The Drax Power (Generating Stations) Order

Applicant's Response to Off-Site Mitigation Strategy Submitted by the Local Authorities

Drax Repower Project

Applicant: DRAX POWER LIMITED
Date: January 2019
Document Ref: 8.4.11
PINS Ref: EN010091

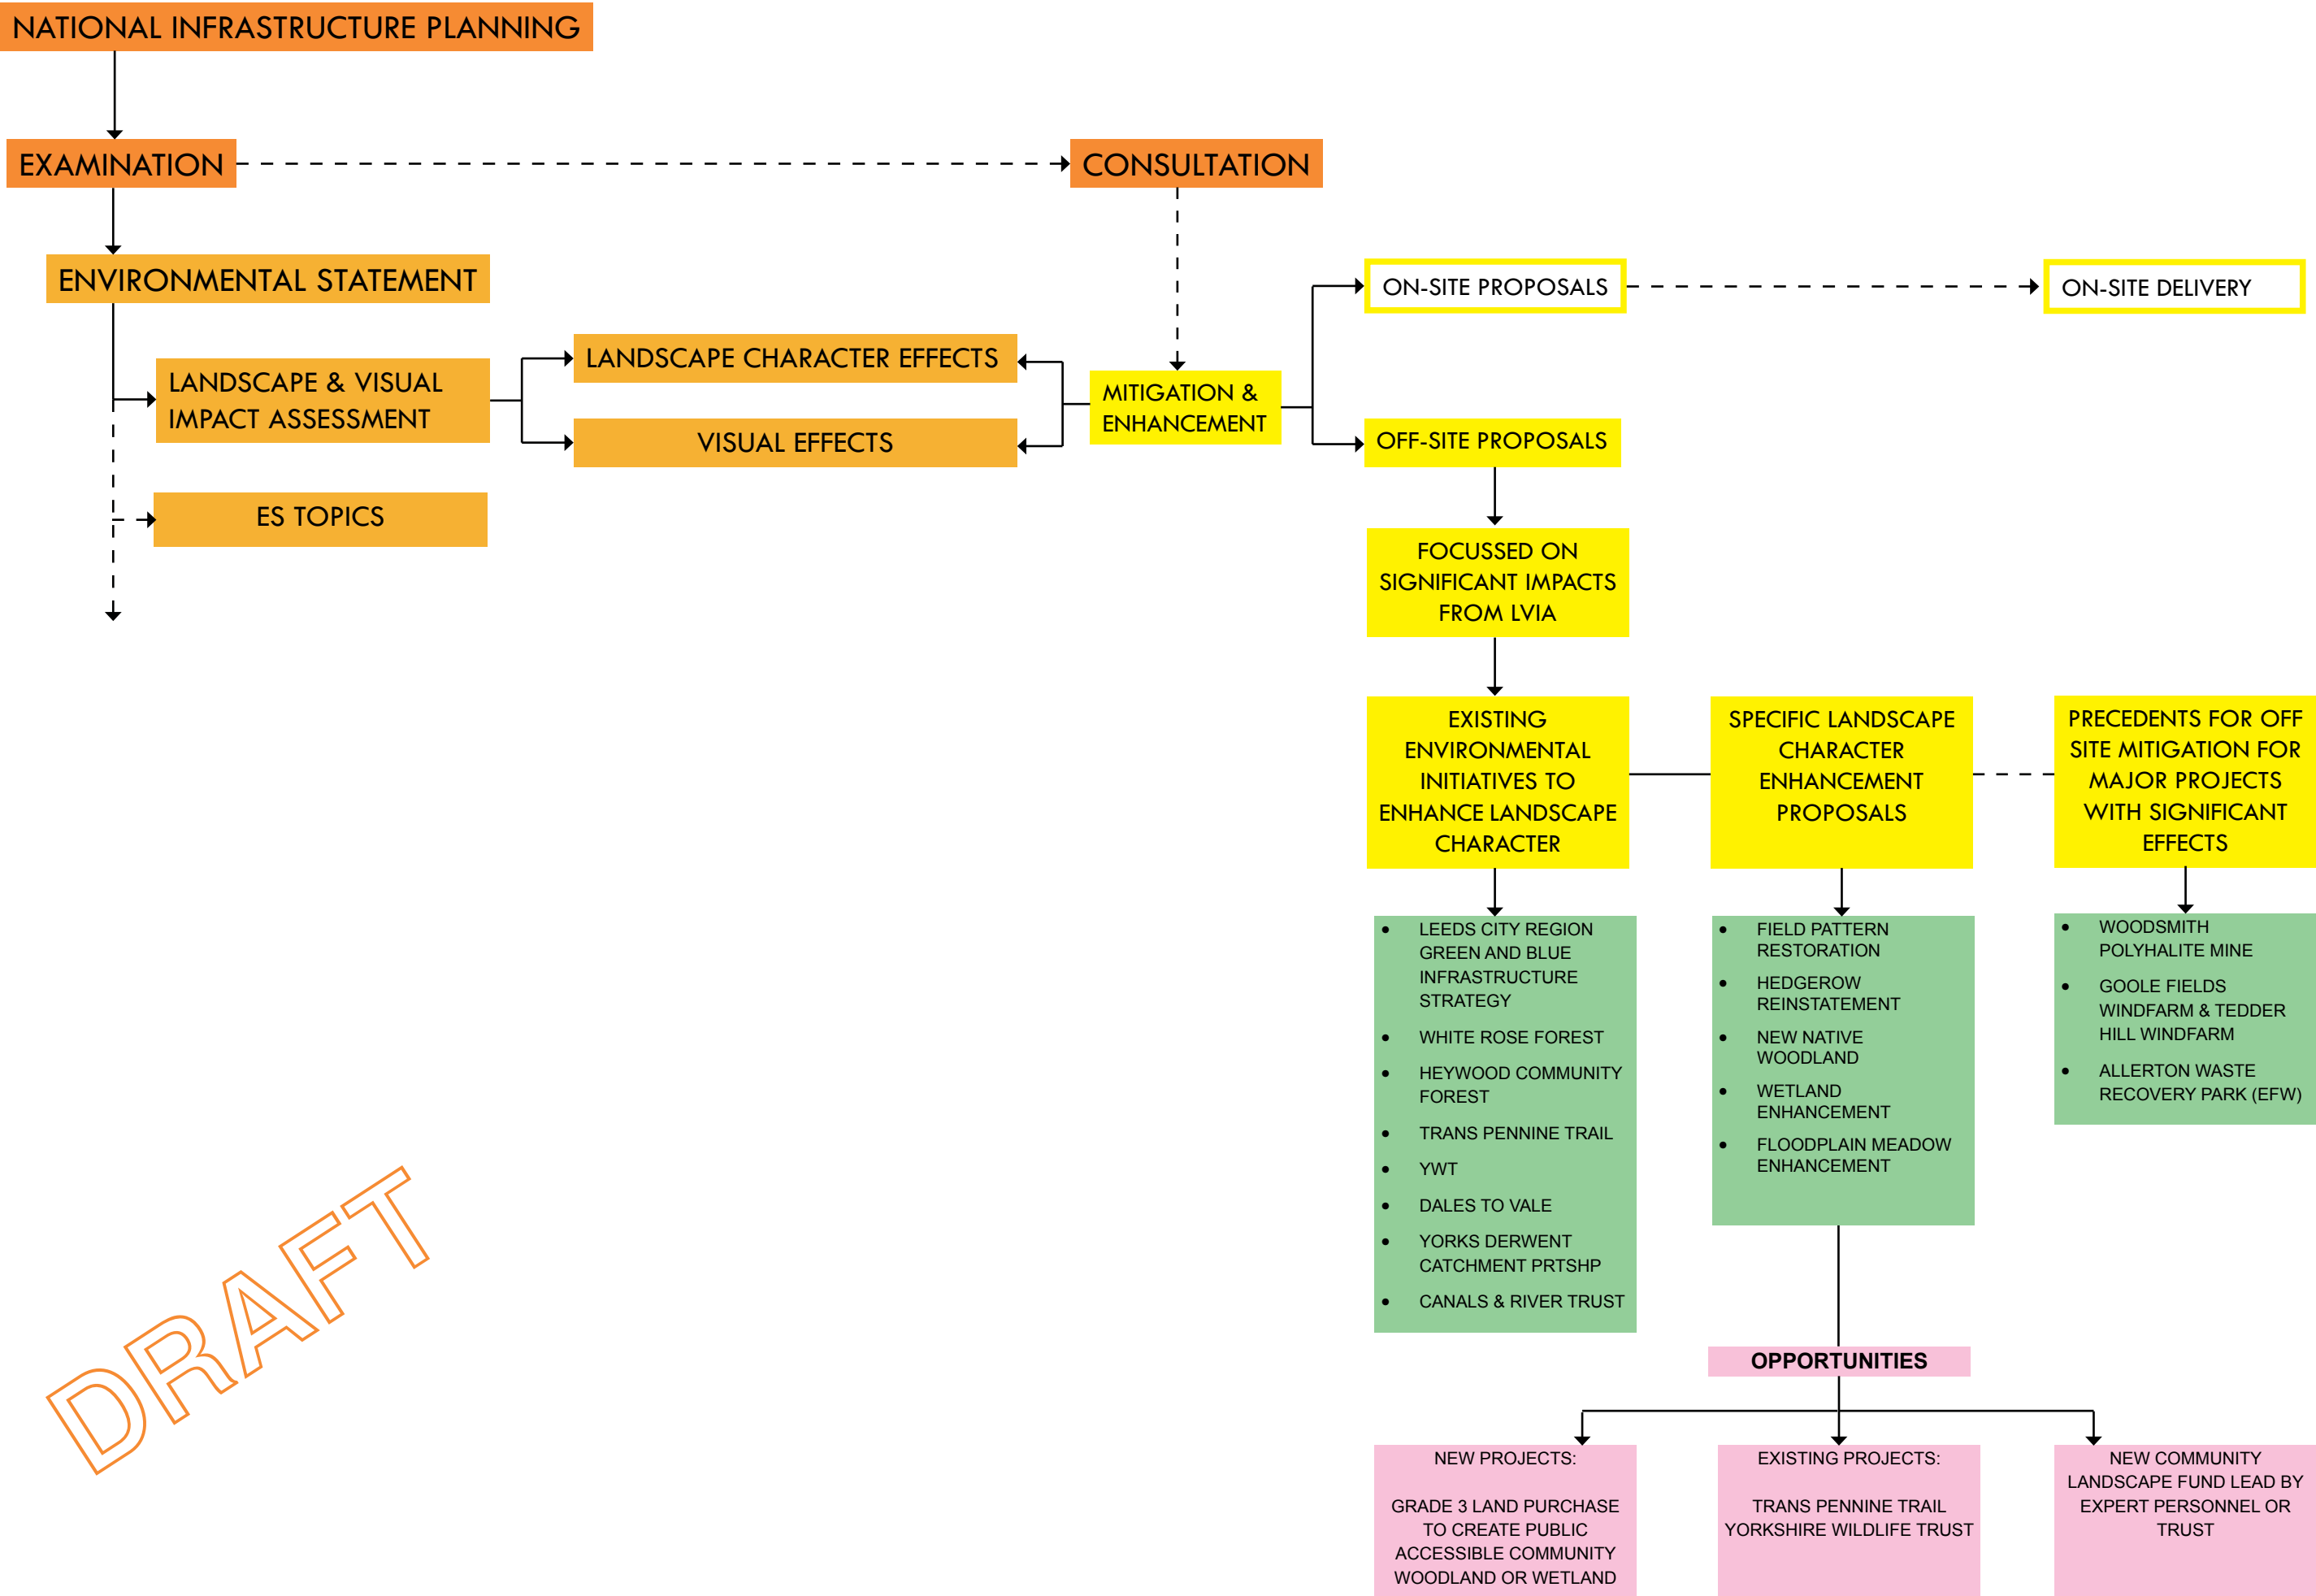
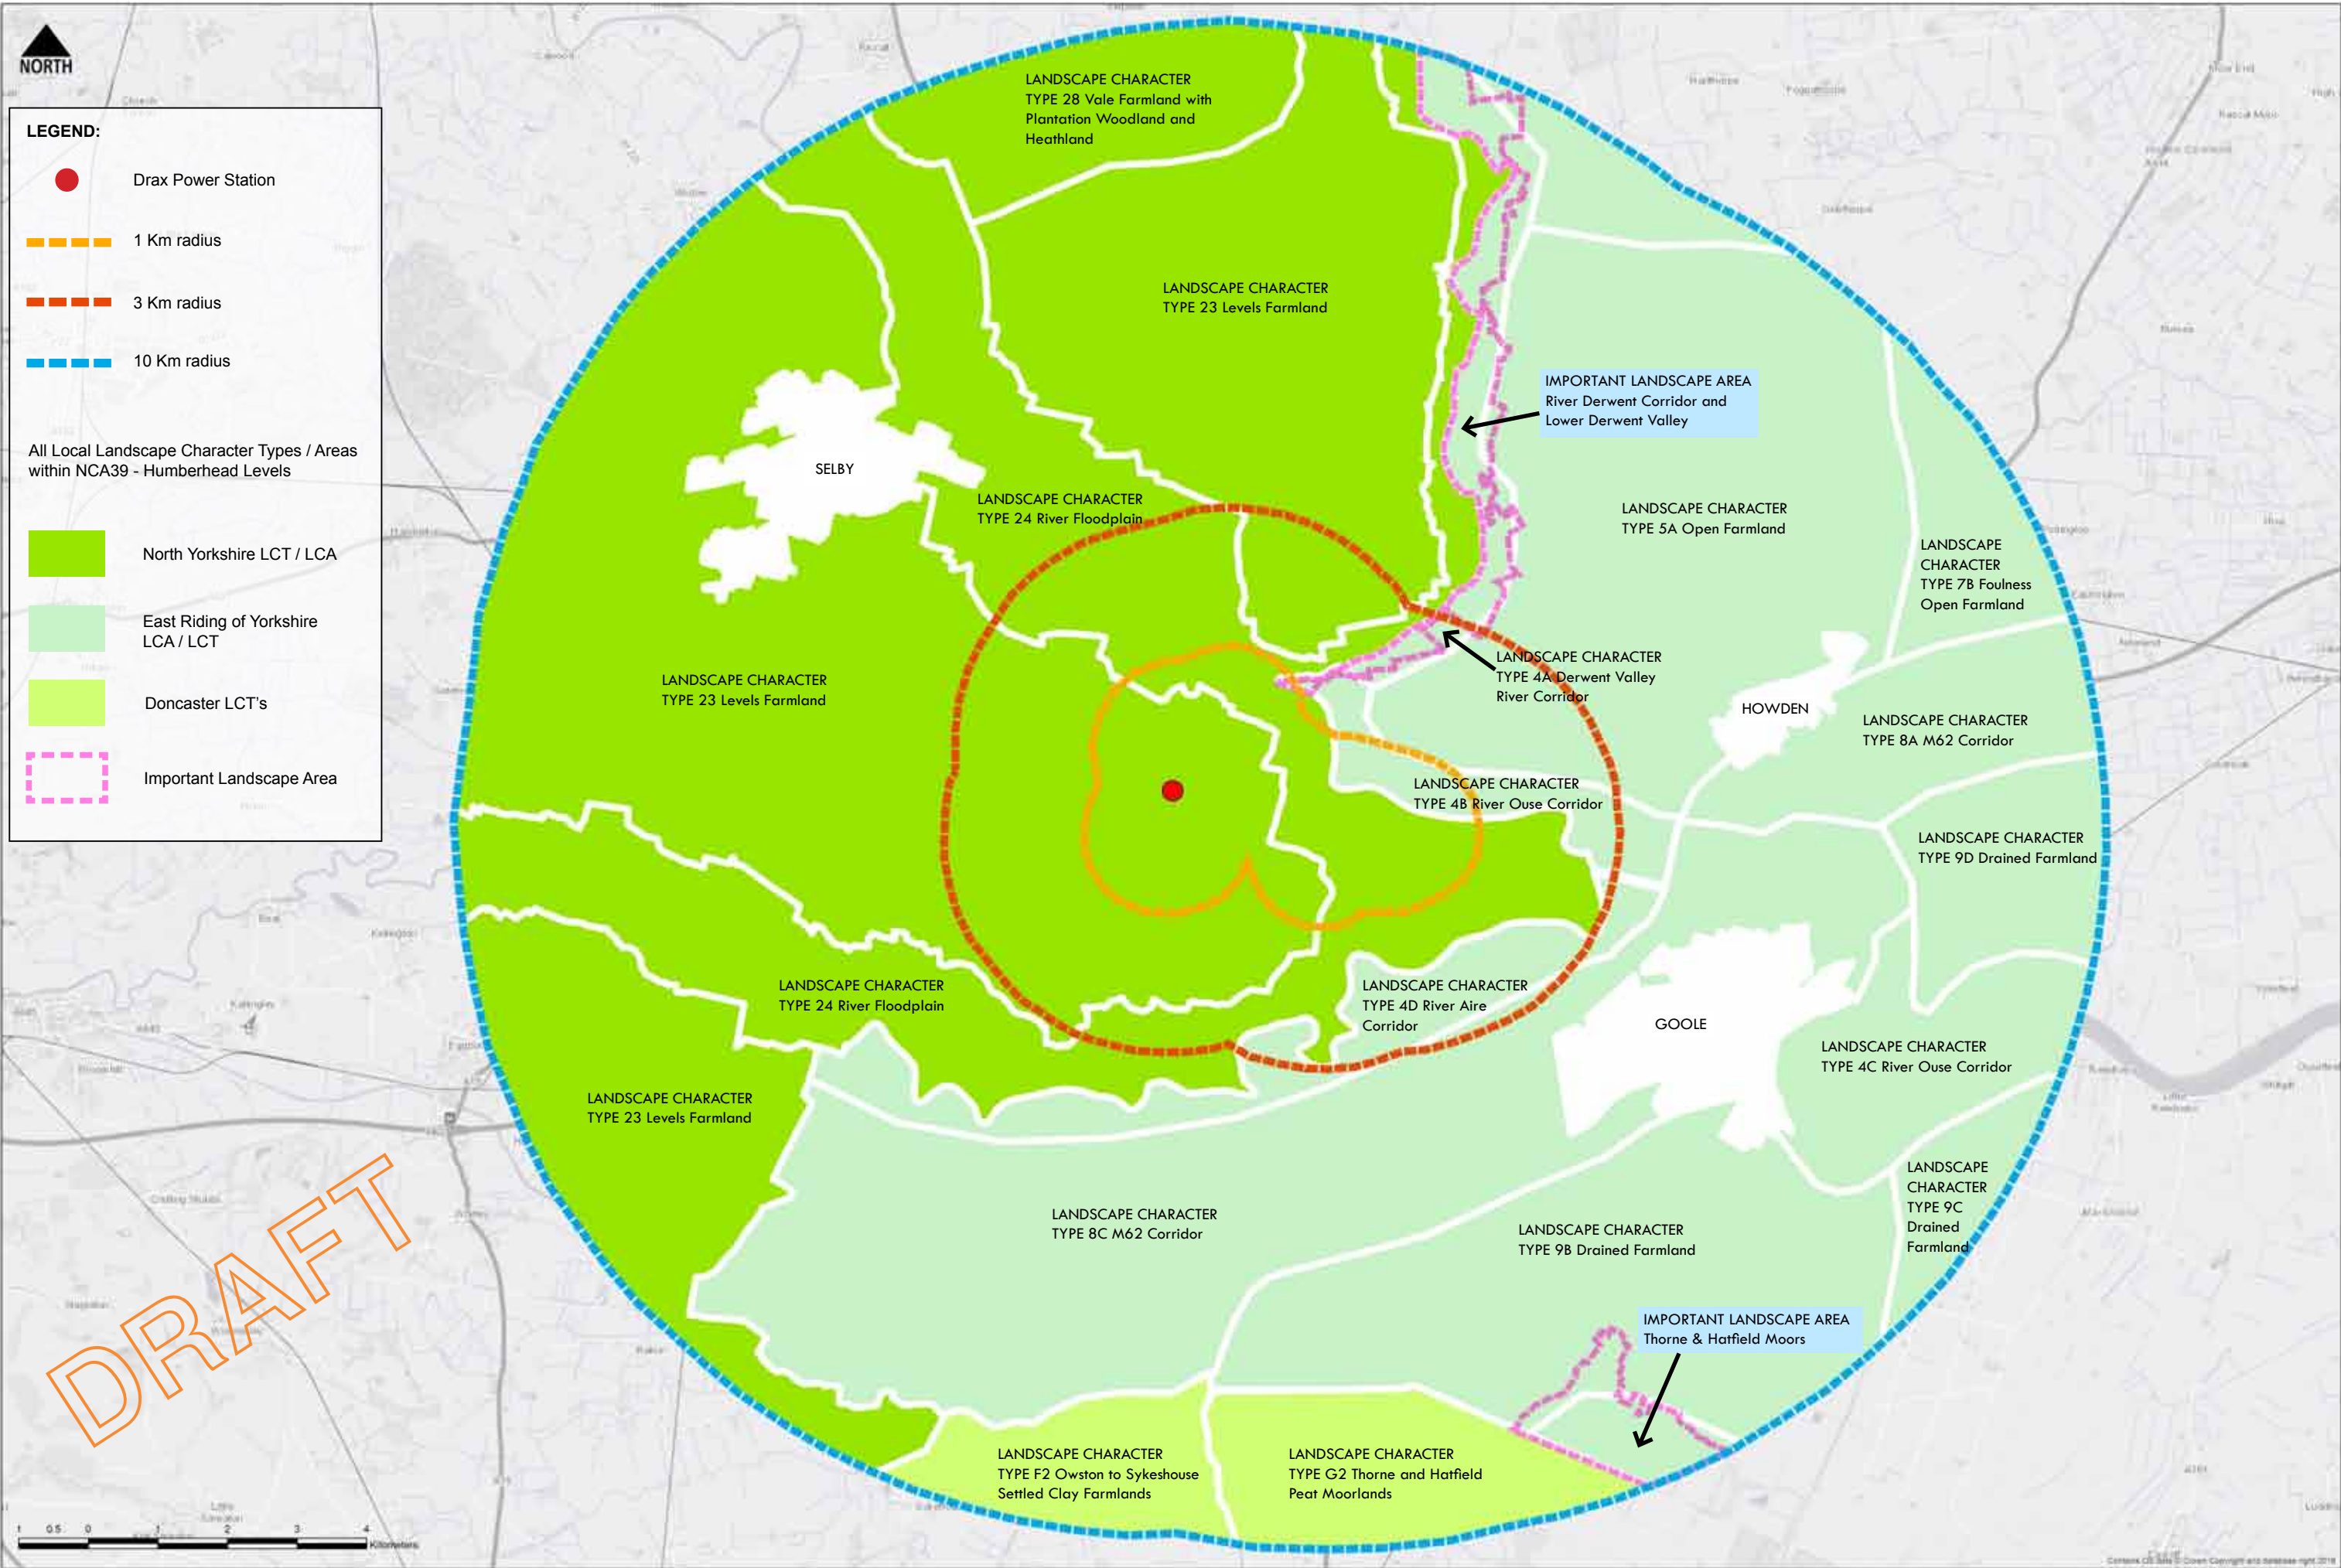
- 2.3.4. The Applicant also disagrees with the presentation of the figures in the OSMS demonstrating the significant effects and covering landscape character and visual effects associated with Public Rights of Way and the Trans Pennine Trail. The figures presented on Pages 4, 5 and 6 of the OSMS provide a "blanket cover" to landscape and visual effects to a distance of 10 km which as outlined above, and in the LVIA, diminish with distance and beyond a 3 km radius. Chapter 10, Landscape and Visual Amenity of the ES makes it very clear that significant effects are based on a "worst case scenario" and there would be effects which are less than the level predicted. Comments relating to each of the figures are summarised in the table below with reference to relevant paragraphs from the ES.

Relevant Figure in the OSMS	Key comments and relevant paragraphs from the ES
Figure on Page 4 illustrates “significant effects on landscape character areas where no off site mitigation / enhancement proposed”	Such effects are based on a “worst case scenario”, and would diminish with distance and beyond a 3 km radius of the Proposed Scheme as outlined in the paragraphs above. Figure on page 4 “reads” as if entire landscape character types defined as moderate – major or moderate adverse would experience significant effects when this is not the case.
Figure on Page 5 illustrates “significant visual effects on Public Rights of Way”.	<p>The LVIA makes it very clear that effects on PRoW are based on a “worst case” scenario and are more noticeable to the northeast, east and southeast of the Existing Drax Power Station Complex and the Proposed Scheme. Effects are dependent on the nature of the view; a direct unfiltered view resulting in a higher level of magnitude of change and therefore significance compared to a view filtered / obscured by intervening built form and vegetation. This is demonstrated in the paragraphs relating to Stage 3 below:</p> <p>Local recreational users within 1 km using the local PRoW network, recreational facilities and sports grounds):</p> <p>Paragraph 10.5.205: <i>“The sensitivity of other recreational users utilising the PRoW network, recreational facilities and sports grounds is medium. Based on a <u>worst case direct and unfiltered view</u> experienced by users within 1 km of the Site, the magnitude of change prior to mitigation would be large to medium. Therefore, there is likely to be a direct, long term effect on immediate residential receptors of moderate - major and moderate adverse significance prior to the implementation of secondary mitigation measures.”</i></p> <p>Paragraph 10.5.206: <i>“A proportion of other recreational receptors within 1 km have partial screening by other development or vegetation or are oriented away from the site. For these, the magnitude of change would <u>vary from small to negligible resulting in a direct, long term effect of minor adverse to negligible adverse significance</u> prior to the implementation of secondary mitigation measures. Such effects are not considered significant.”</i></p> <p>Local recreational users between 1 and 3 km using the local PRoW network, recreational facilities and sports grounds:</p>

Relevant Figure in the OSMS	Key comments and relevant paragraphs from the ES
	<p>Paragraph 10.5.208: <i>“The sensitivity of other recreational users utilising the PRow network, recreational facilities and sports grounds and who would experience a direct view is considered to be medium. Based on a <u>worst case view</u>, the magnitude of change prior to mitigation experienced by such users between 1 & 3 km of the Site who have a direct and unfiltered view is medium. Therefore, there is likely to be a direct, long term effect on recreational users of moderate adverse prior to the implementation of mitigation measure and this is considered a significant effect. As above remaining recreational users would experience a range of effects from minor adverse to negligible adverse significance prior to the implementation of secondary mitigation measures.”</i></p>
<p>Figure on Page 6 illustrates “significant visual effects on Trans Pennine Trail”.</p>	<p>The LVIA makes it very clear that effects on the Trans Pennine Trail are based on a “worst case” scenario and that effects would be based on a direct, unfiltered view as demonstrated in the following paragraphs relating to Stage 3:</p> <p>Local recreational users within 1 km of the Site:</p> <p>Paragraph 10.5.204: <i>“The sensitivity of recreational users using the TPT and NCN to the north of the River Ouse is high. Based on a worst case direct and unfiltered view the change arising from Stage 3 would be of medium magnitude. This would give rise to a direct, long term moderate – major adverse significant effect on recreational users of the TPT and NCN prior to the implementation of secondary mitigation measures.”</i></p> <p>Local recreational users between 1 and 3 km of the Site:</p> <p>Paragraph 10.5.207 <i>“The sensitivity of recreational users on the TPT and NCN to the north of the River Ouse is considered to be high. Based on worst case views, the change arising from Stage 3 would be of medium magnitude. This would give rise to a direct, long term moderate - major adverse significant effect on recreational users of the TPT and NCN prior to the implementation of secondary mitigation measures.”</i></p> <p>In addition, the Applicant questions why the entire 1 and 3 km radius for the figure on Page 6 is shown as significant when effects solely relate to 1 and 3 km distances from the Trans Pennine Trail and considers the figure has</p>

Relevant Figure in the OSMS	Key comments and relevant paragraphs from the ES
	overexaggerated the extent of effects visually.
